Pagham Parish Council considered the following applications at a meeting of its Planning Committee Advisory Group on 10th August 2021. In accordance with a scheme of delegation dated 4th May 2021, the Clerk submits the following comments:

6.2 P/111/21/RES – Land adjacent to Sefter School House Sefter Road Pagham PO21 3EE. Approval of reserved matters following P/116/19/OUT for the erection of 2No detached houses and 4 no semi detached dwellings.

RECOMMENDATION: OBJECT. The Council wishes to object to the application on the following grounds:

Project
Land adjacent to Seftor School House
Seftor Road
Bignor Regis
PO21 3EE
Drawing Title
Plot 1
Floor Plans and Section

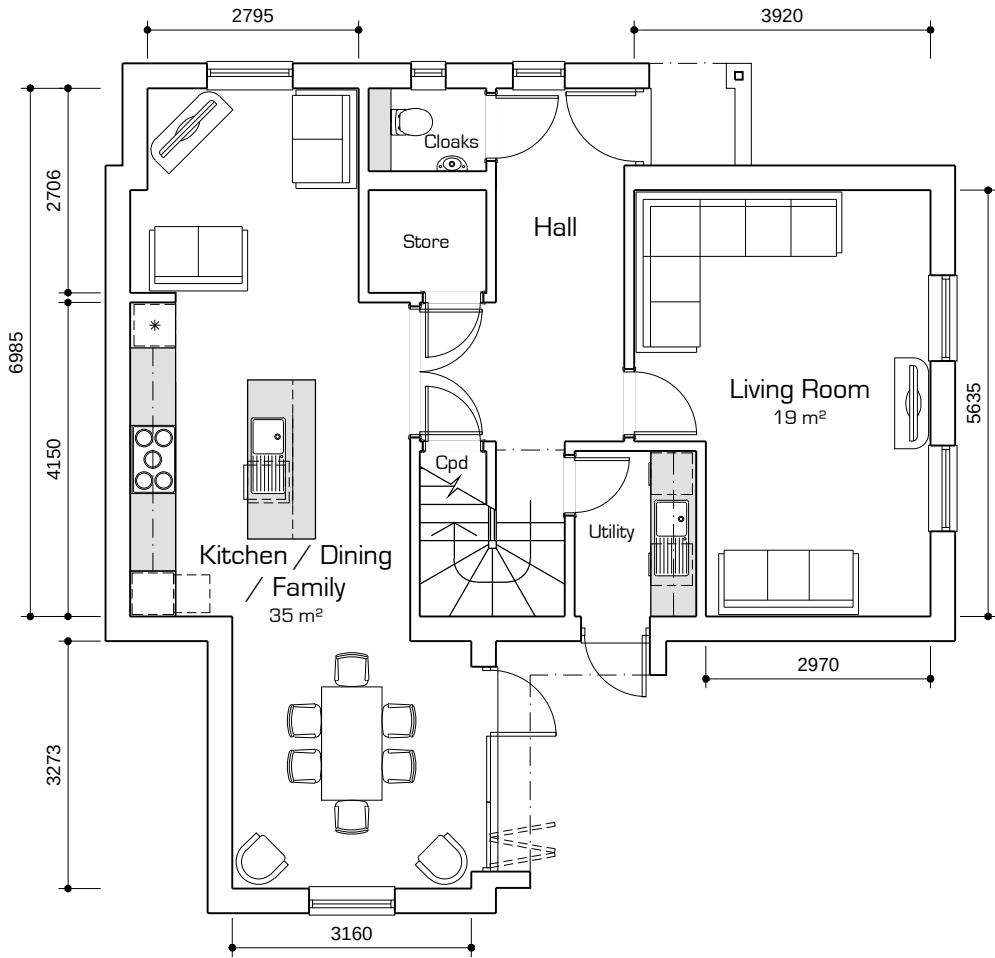
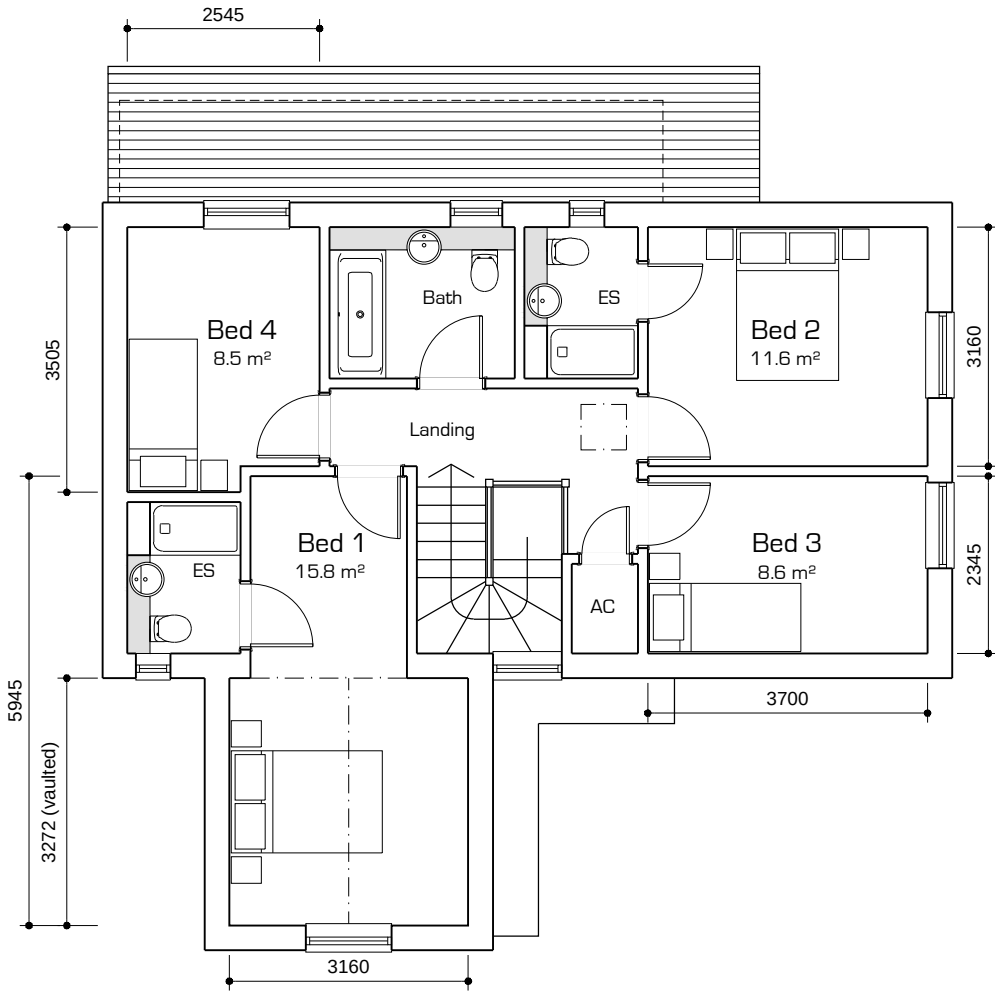
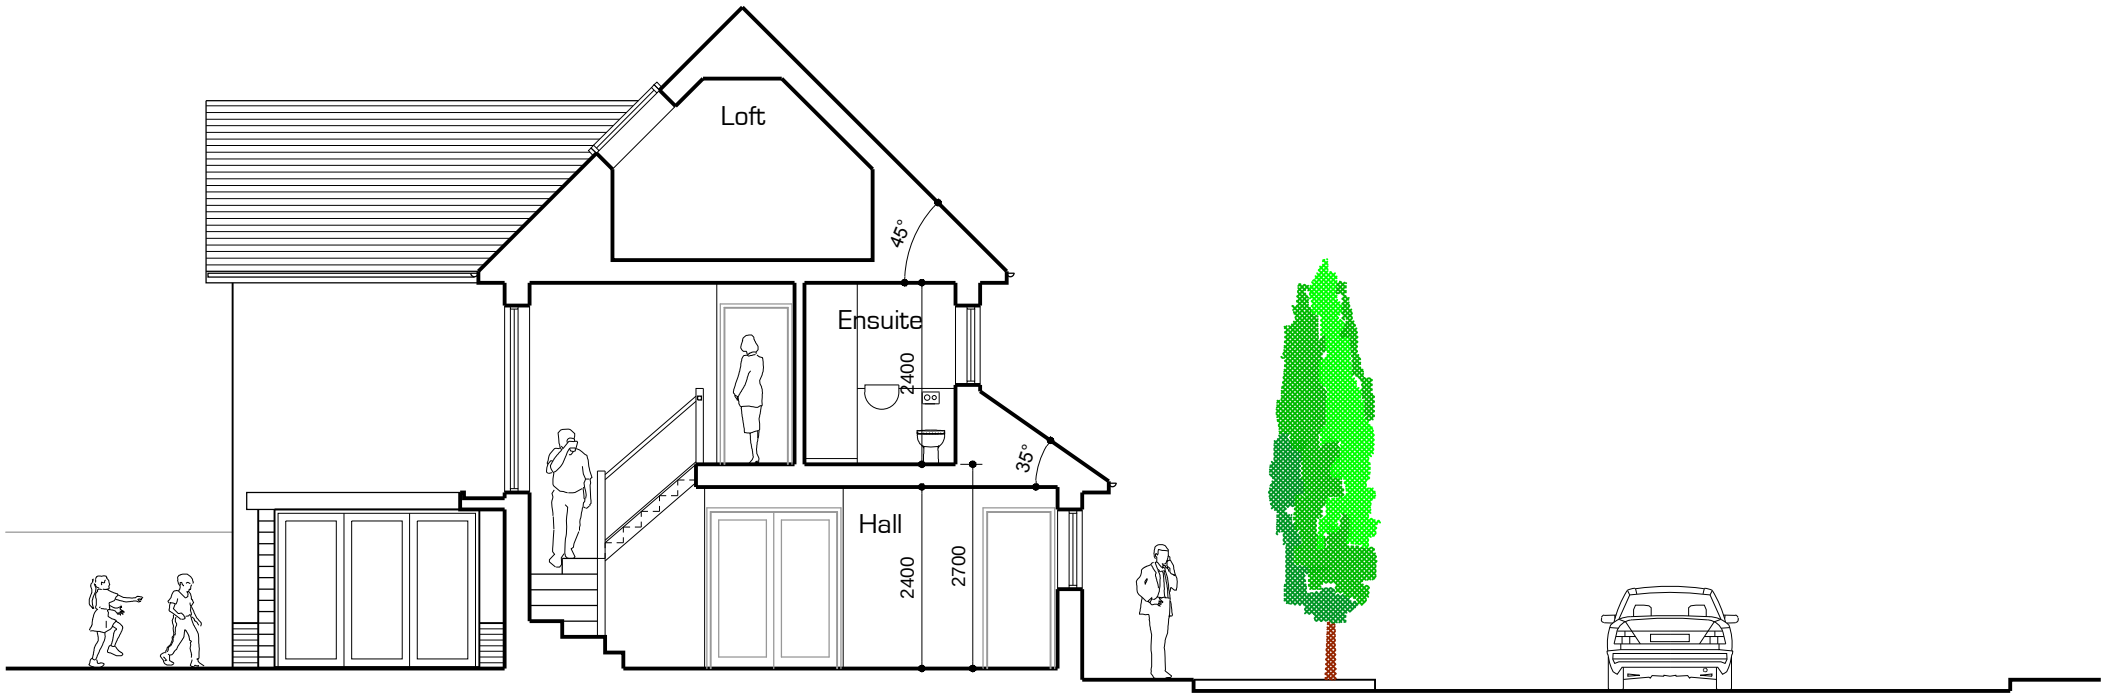
- Plots 1 & 2 have very limited outdoor space for 4 bedroom houses.
- There is limited communal open space provided. The area at the front of the estate, which would inevitably attract children as a play space, is too near the access to Sefter Road.

Project
Land adjacent to Seftor School House
Seftor Road
Bignor Regis
PO21 3EE
Drawing Title
Plot 1
Elevations

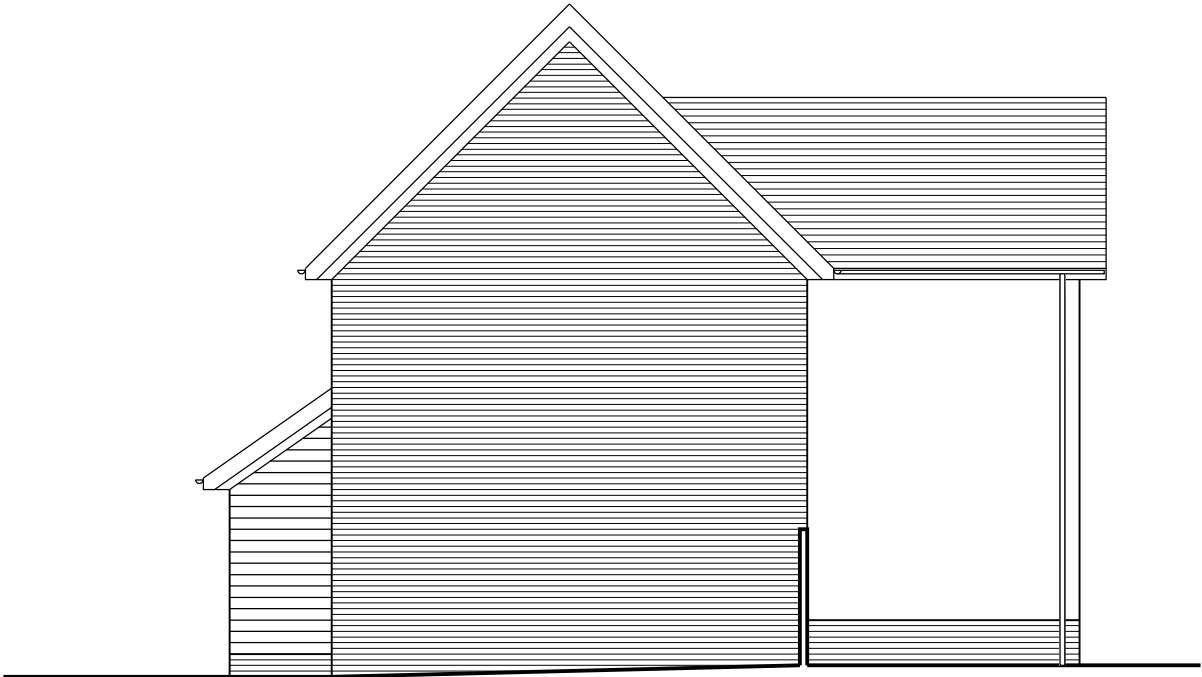
- The access is still not considered safe.
- The design of the properties is not appropriate for the rural location of the site. It is not in keeping with other properties in the area. The use of white upvc windows, white weatherboarding is not consistent with rural feel.
